RE: Staff Review Comments for Level II Preliminary Site Plan

Project Name: Pomeroy Street Construction  
Applicant: Chabad Lubavitch of Maine, Inc.  
Planner: Nell Donaldson

Project ID: 2012-471  
CBL: 193-E-1

SITE PLAN
LEVEL I-MINOR RESIDENTIAL DEV.
LEVEL II-ROAD IMPROVEMENTS
LAND OF
CHABAD LUBAVITCH OF MAINE INC.
POMEROY STREET
PORTLAND, MAINE

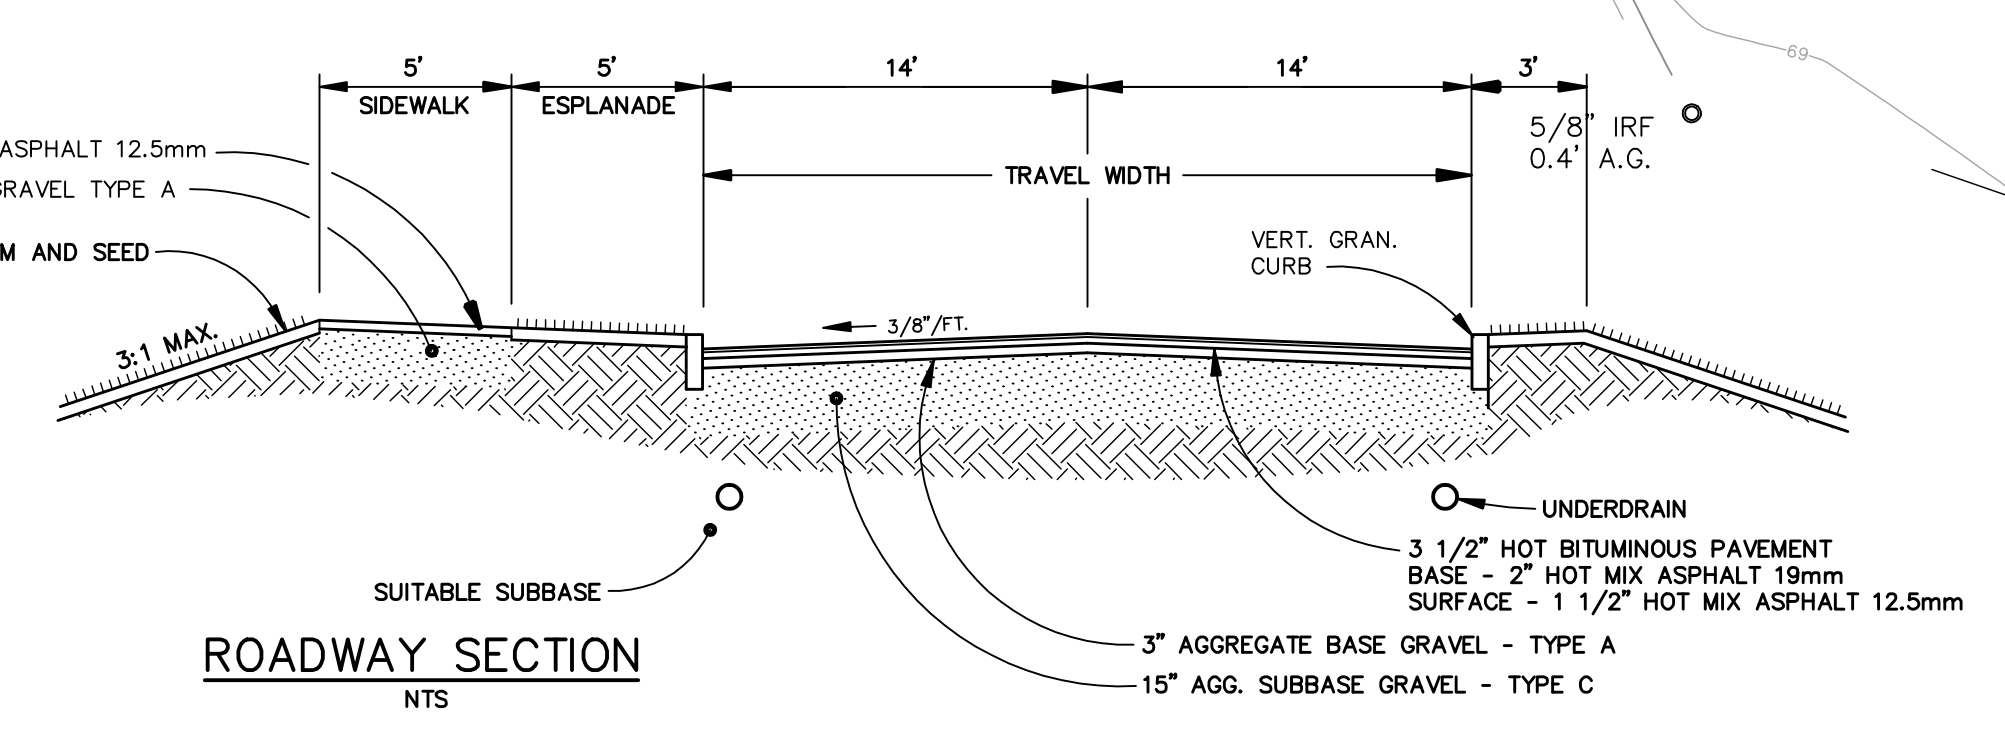
- A turnaround is required at the end of the proposed street, per the *City of Portland Technical Manual* and the Department of Public Services. Please define with easements.

- The site plan proposes two drainage pipe inlets located on either side of the residential driveway. These inlets have proposed invert elevations that are below the existing ground surface elevation, and are located in close proximity to existing wetlands. Surface and shallow groundwater associated with these wetland areas will likely enter the roadway drainage system through these inlets, affecting the hydrology of the adjacent wetland areas. Although review of wetland impacts will be performed by MaineDEP, the addition of this “non-contaminated” water source into a drainage system that discharges into the city’s combined sewer is not allowed unless approved by the City Engineer (Section 2.1.1 of *City of Portland Technical Manual*).

- The proposed pipe into existing sanitary manhole does not meet *Technical Manual* standards.
- Drain manholes shall have channels installed.
- All precast structure castings shall meet *Technical Manual* requirements or approved equal.

- Street light spacing and type should meet *Technical Manual* requirements. I am checking on the statement made in Note 21 stating that CMP will supply. This assumption may change.

STANDARD BOUNDARY
 SURVEY AND EXISTING
 CONDITIONS PLAN
 LAND OF
 CHABAD LUBAVITCH OF MAINE INC.
 POMEROY STREET
 PORTLAND, MAINE

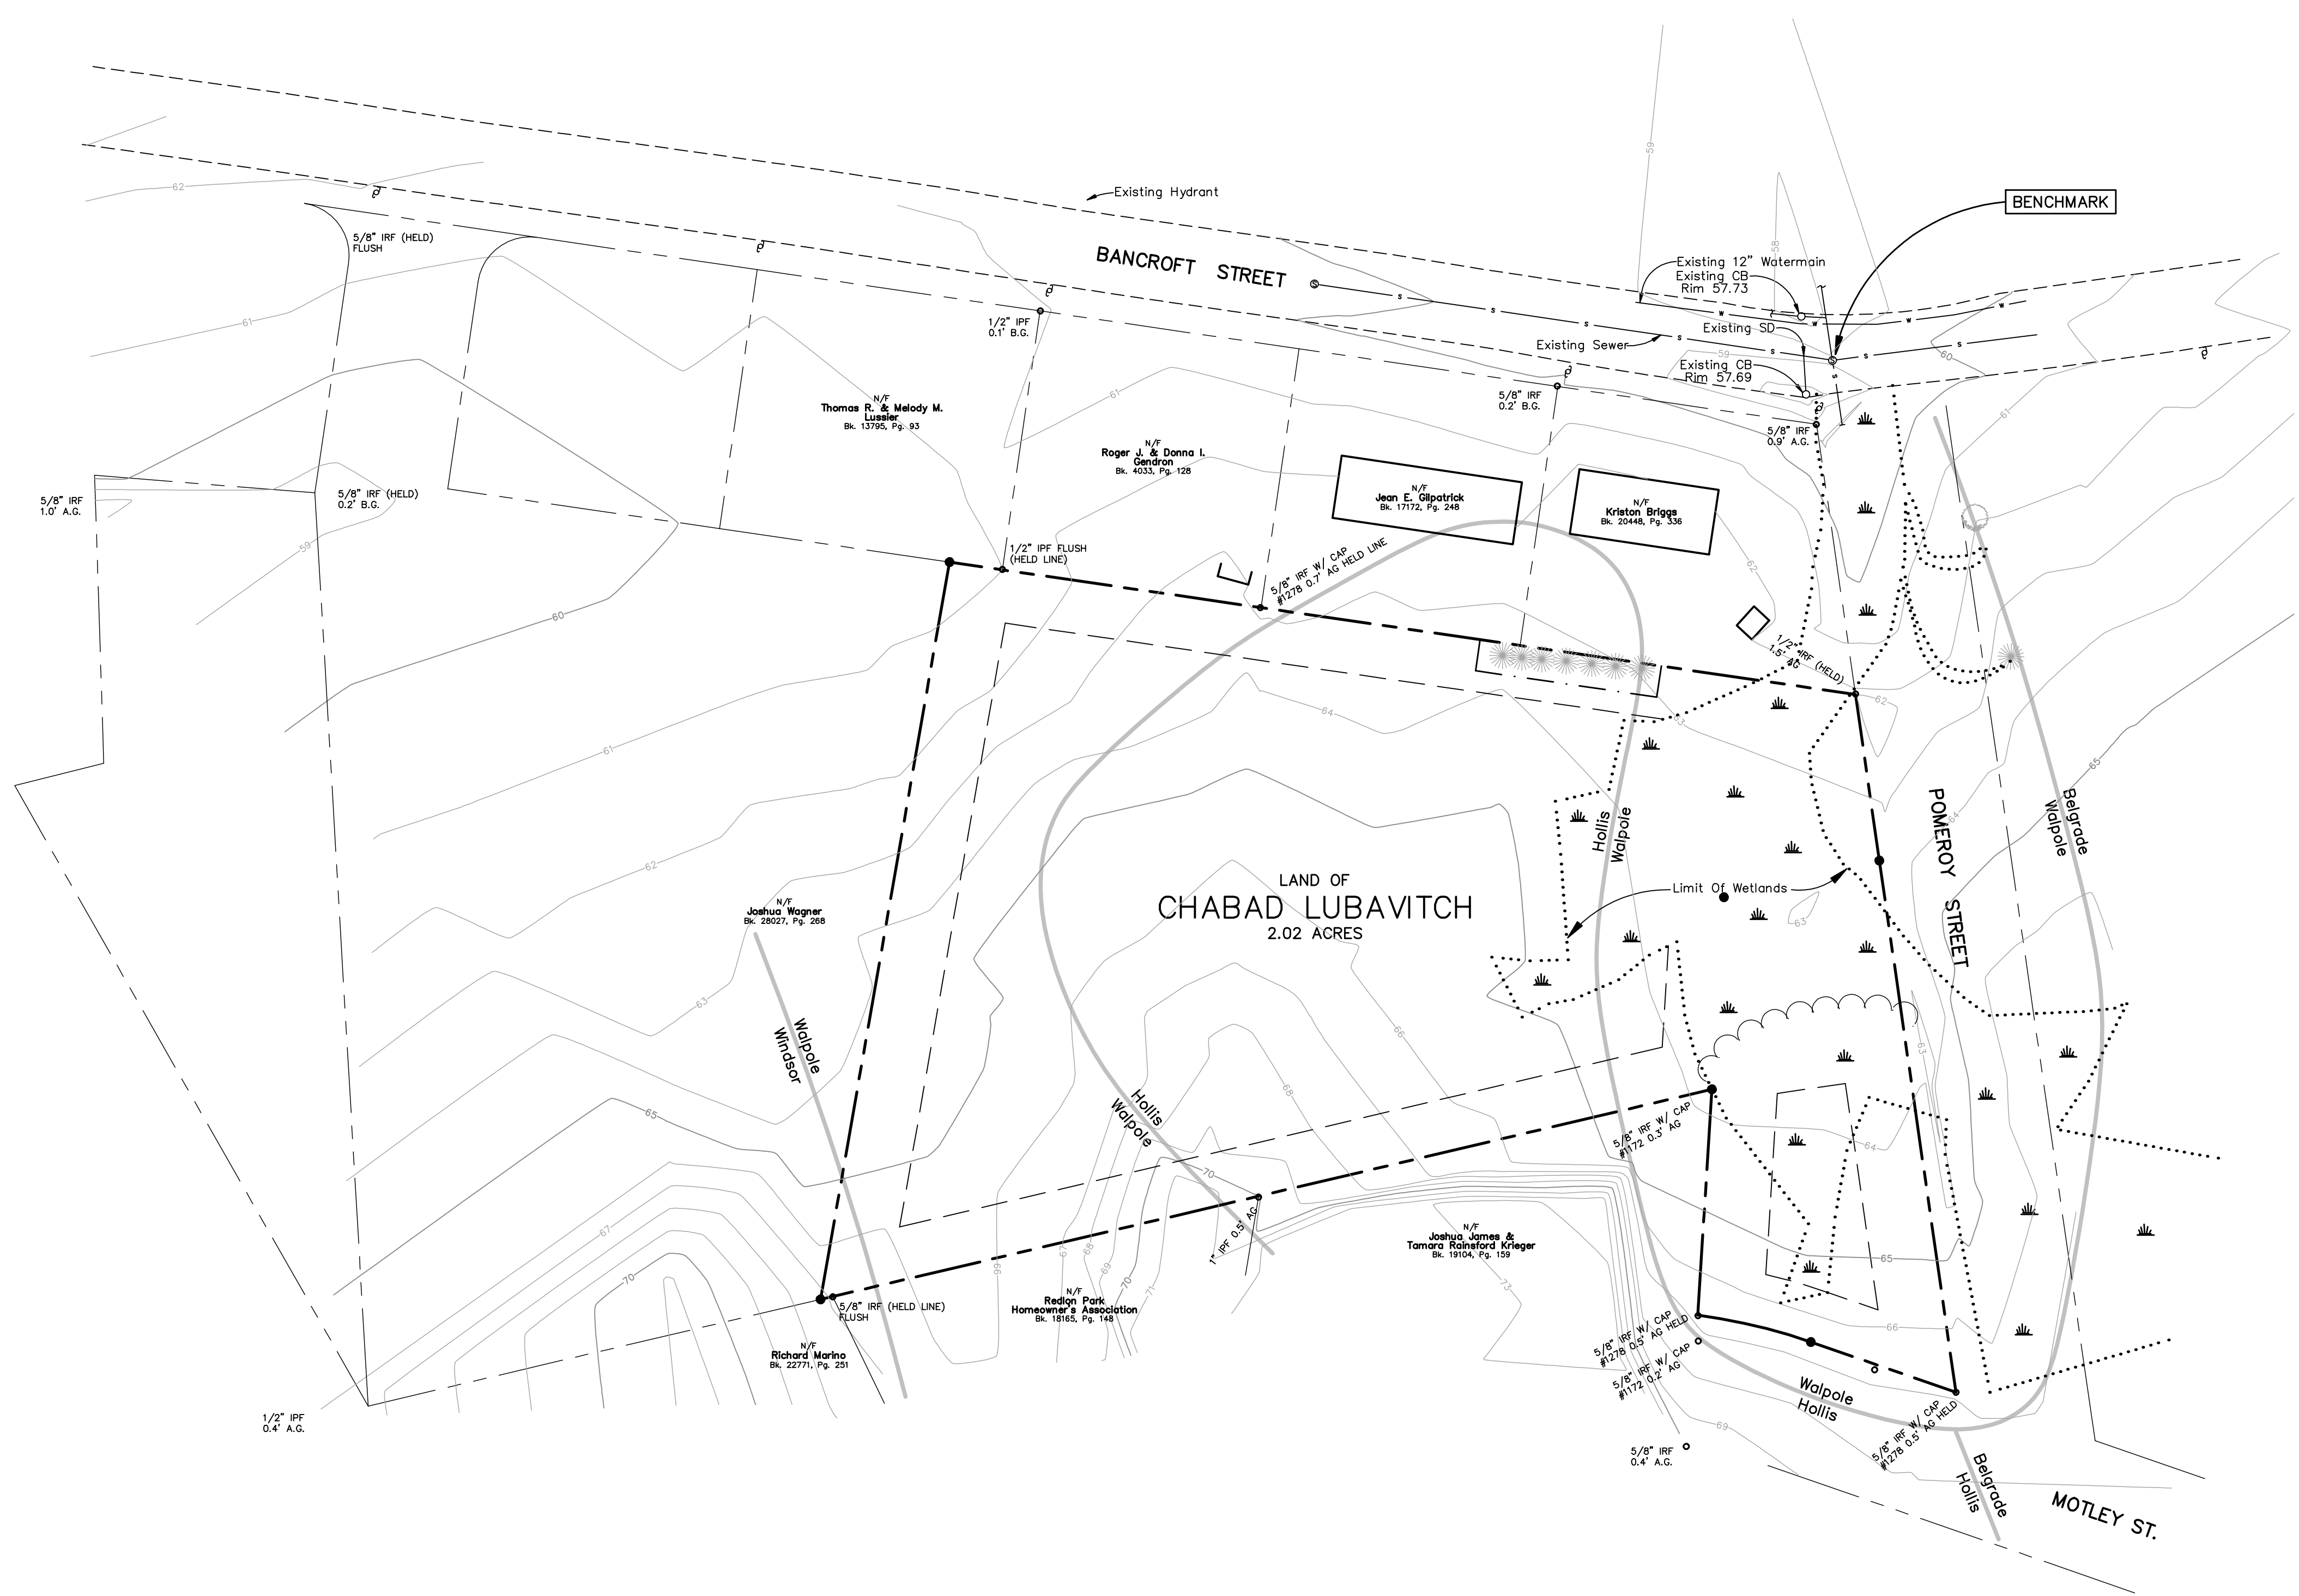
1. Please add a note to plans that all work within the proposed Pomeroy Street right-of-way shall meet *City of Portland Technical Manual* standards.
2. On Sheet 1 please indicate the status of the streets shown (i.e. accepted, vacated, paper, etc). In addition, please show Kenilworth Street. A separate survey plan for acceptance is suggested.

3. Please indicate the total right-of-way width and distances to property lines on Sheet 1.
4. Sheet 1 should be on the Maine State Plane for acceptance.

5. Sanitary manhole rims are not acceptable as an official city benchmark.
6. Please define the area of Pomeroy St. to be accepted with linework, bearings and distances and granite survey monuments.

PEDESTRIAN RAMP
N.T.S.

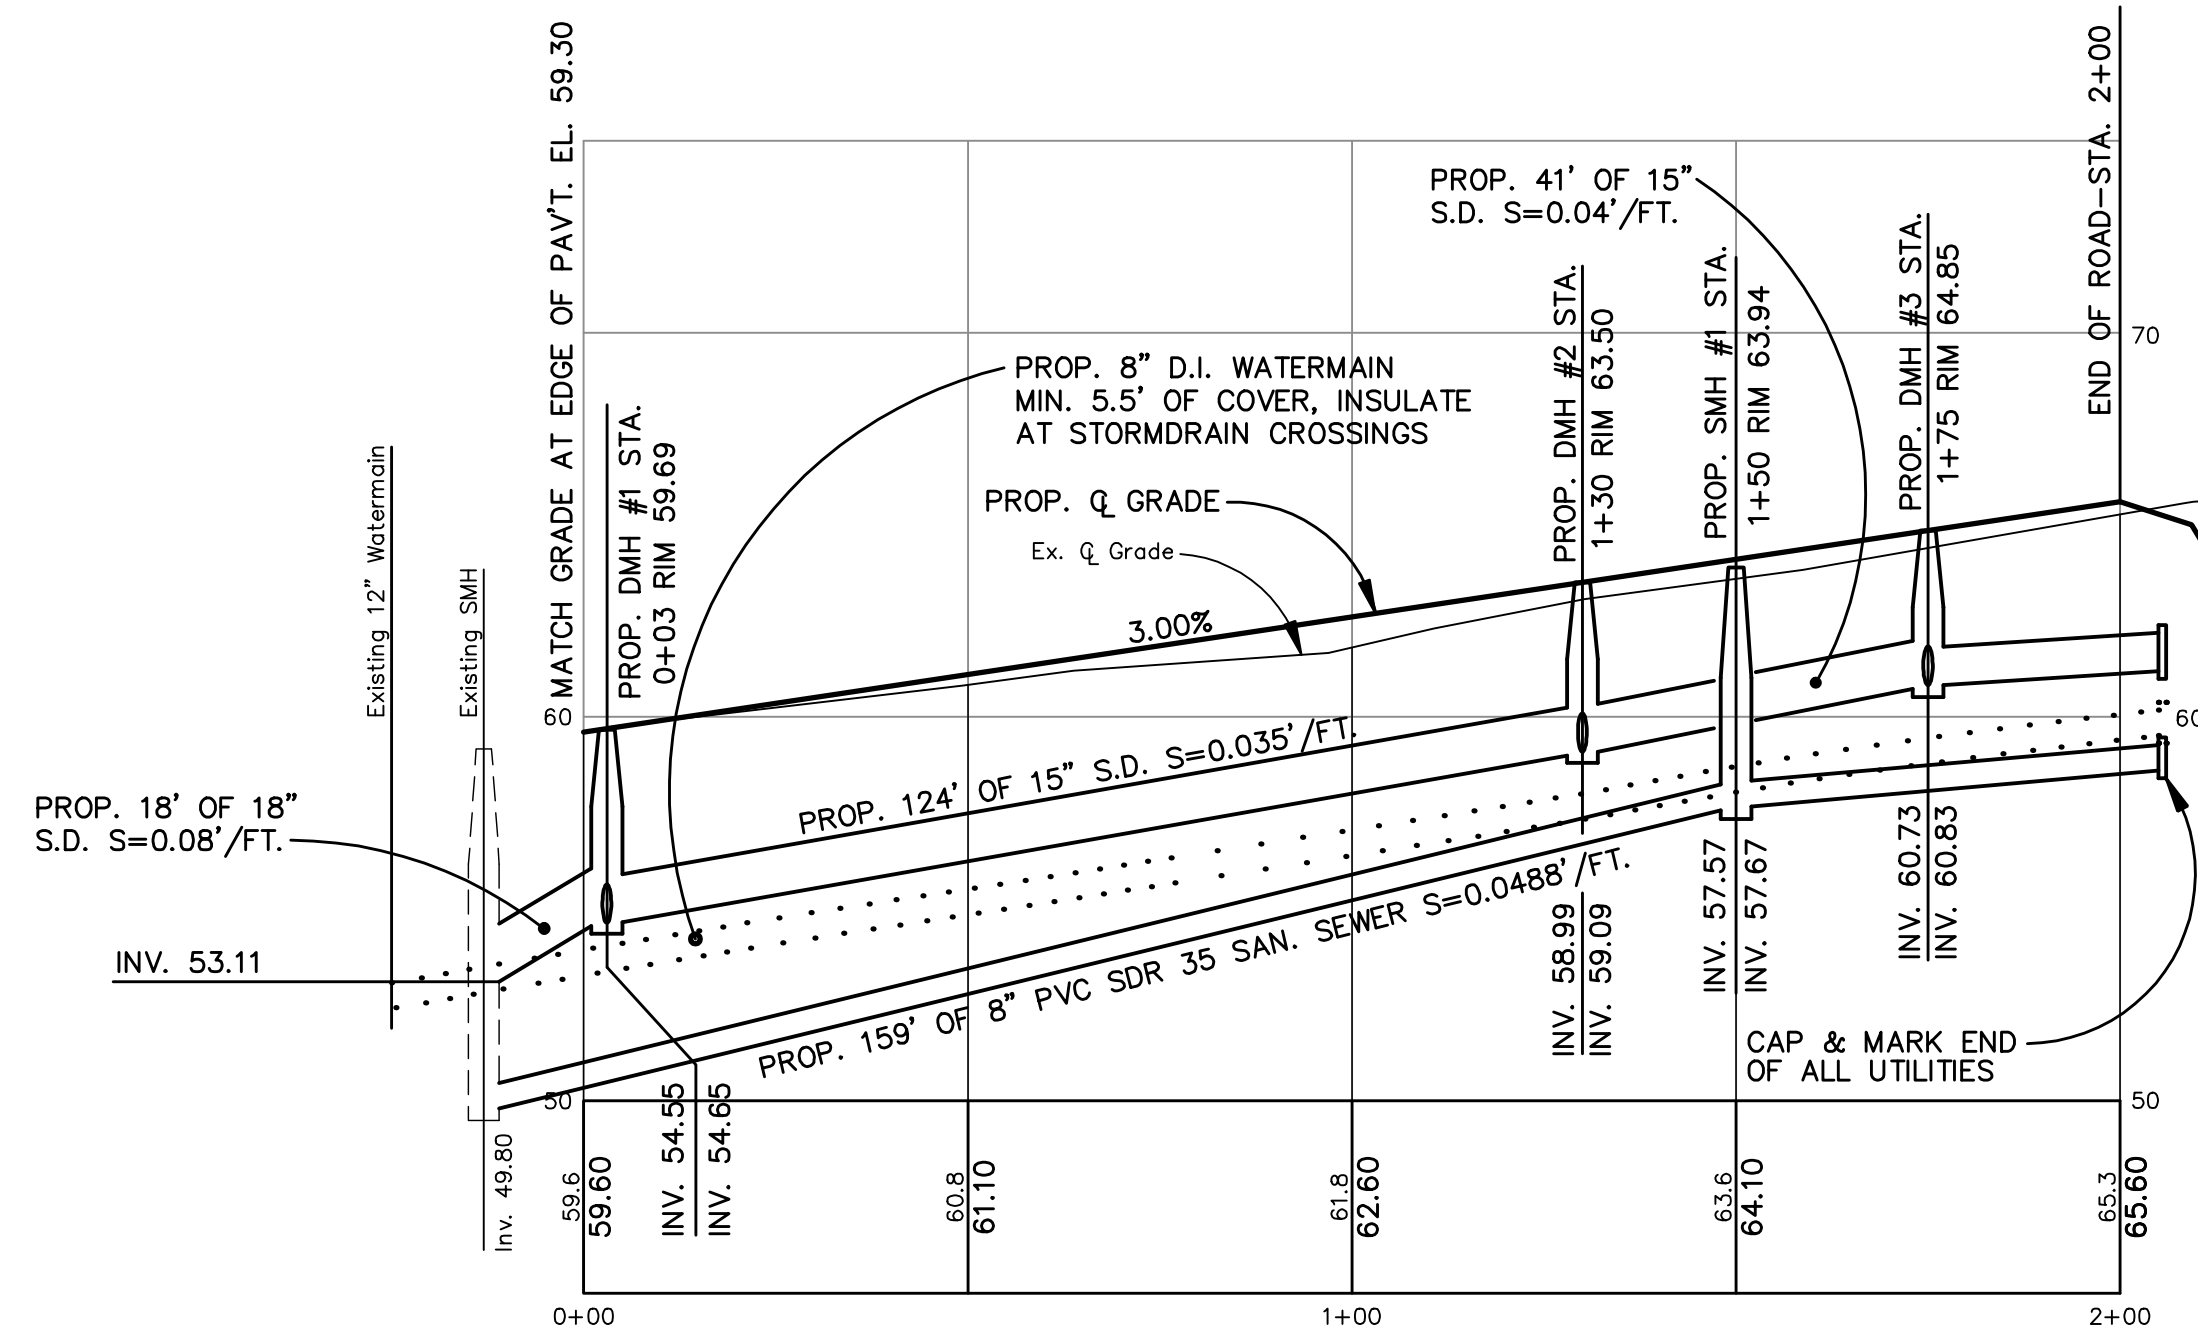
- Sidewalk crossing details with ADA warning strip shall be reviewed and approved by Bruce Hyman (400-9243) of the Department of Public Services.
